RE: ST FRANCIS COLLEGE STAGE 1 - LANDSCAPING (SSD-10365)

City Plan Strategy & Development P/L (City Plan) acts on behalf of the proponent of the abovementioned application. This correspondence responds to the NSW Department of Planning, Industry & Environment's (DPIE) request for additional information in relation to the abovementioned application, dated 11 August 2020. DPIE's request also sought a response to submissions received from the public as well as other government agencies during the application's exhibition period.

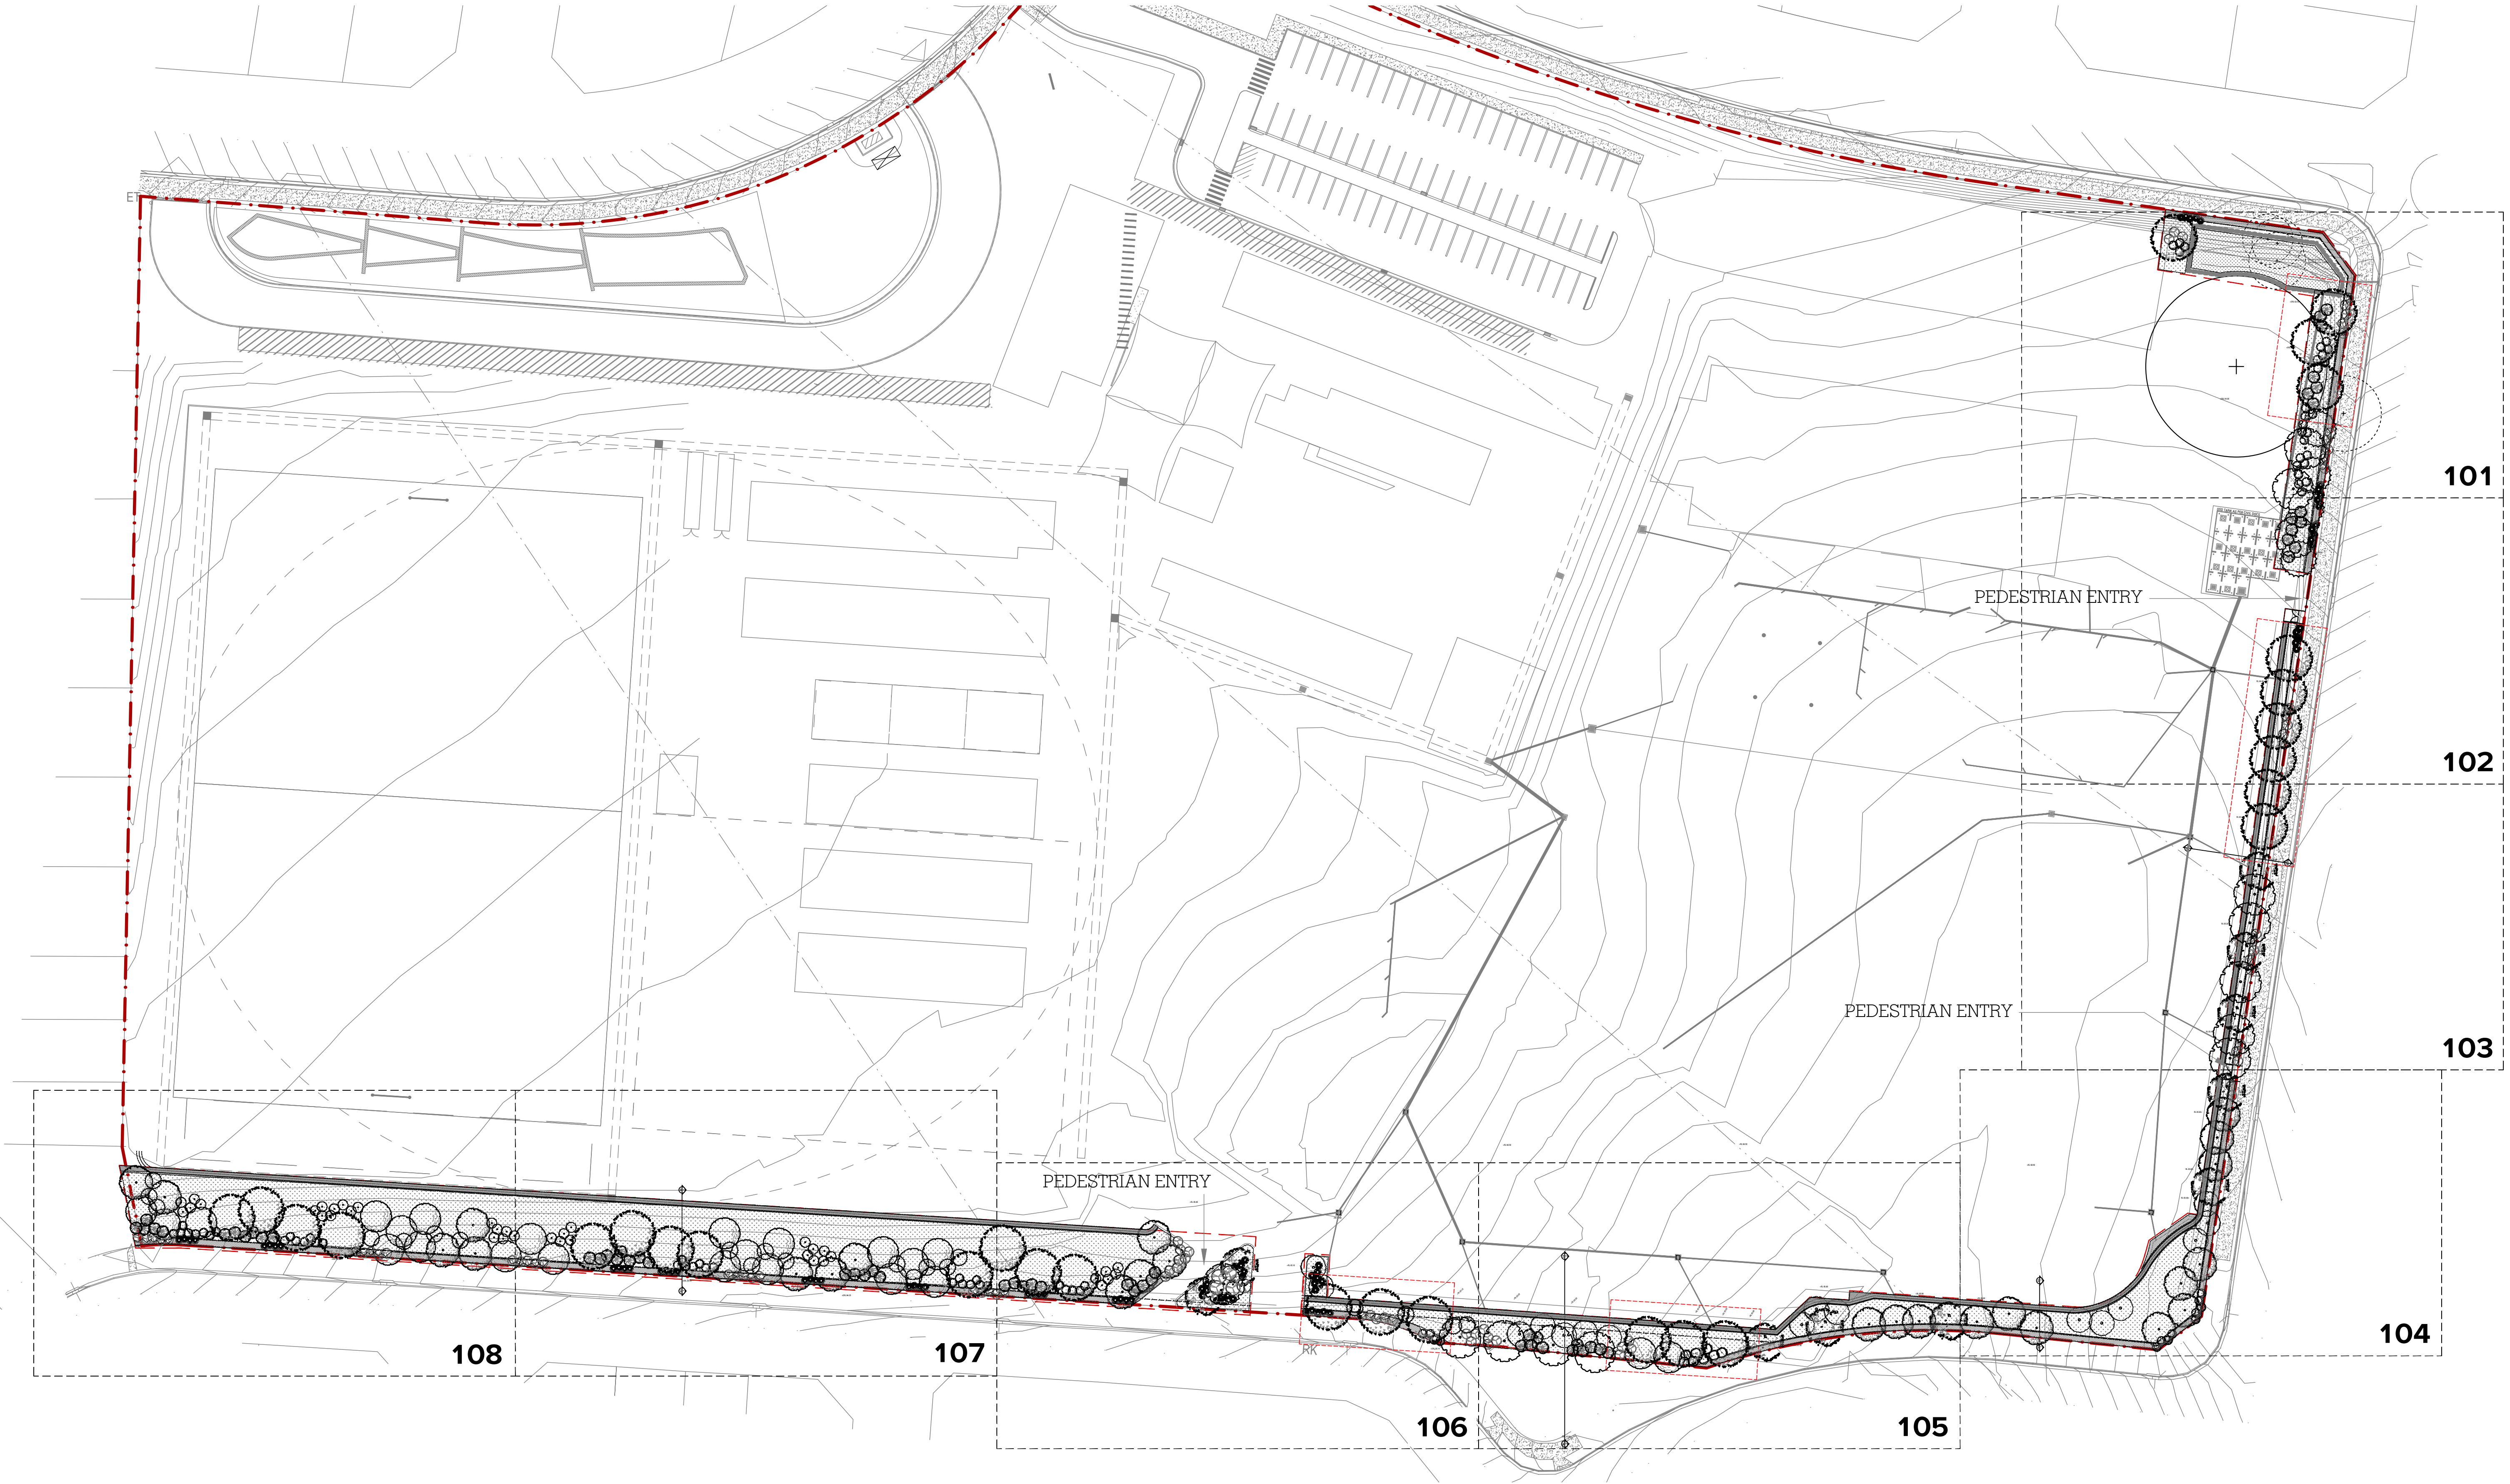
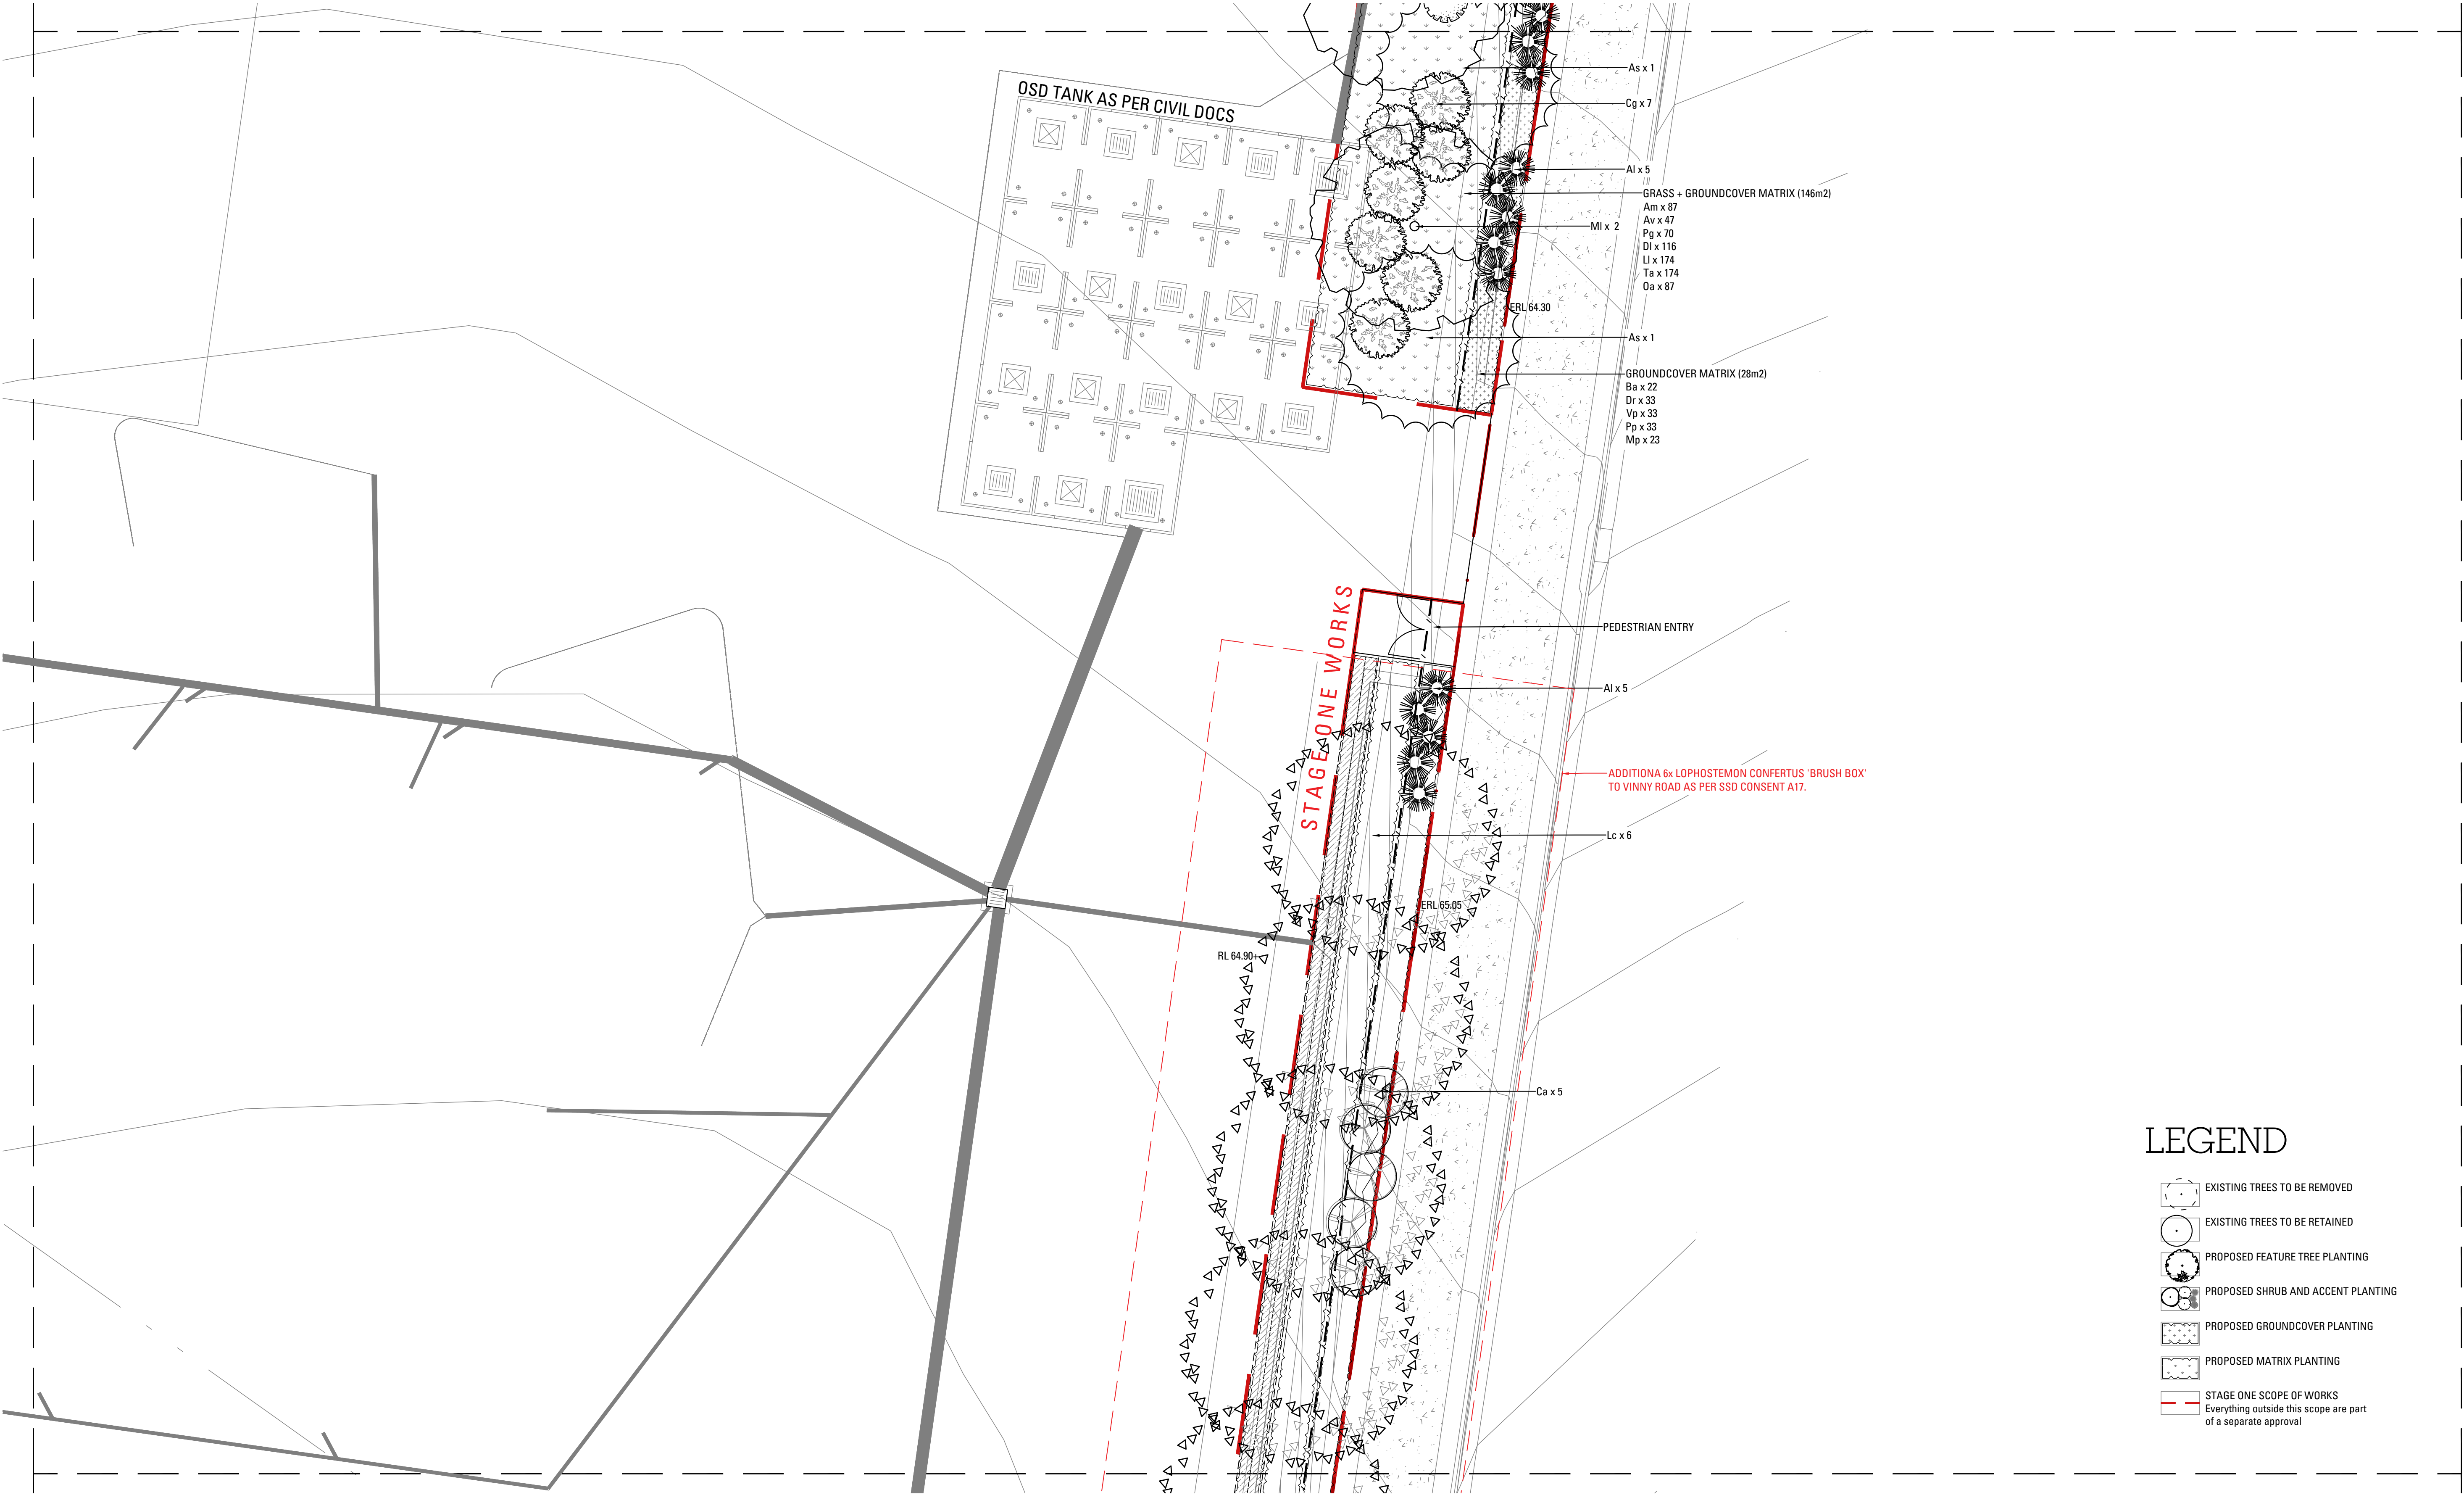
1. CLARIFICATION OF DEVELOPMENT FOOTPRINT

3. PEDESTRIAN ENTRIES

The landscape plan has been amended to include a revised legend. The legend includes a red dashed line which represents the proposed development area. A red dashed line is now clearly shown on the plan itself. The amended landscape plan accompanies this correspondence separately.

The pedestrian entries were erroneously omitted from the proposed landscape plan. An amended plan accompanies this correspondence which includes three (3) pedestrian entry points, consistent with the original Concept Approval SSD 8832. For information, an extract of the amended landscape plan showing the pedestrian entry points circled blue, is provided on the following page.
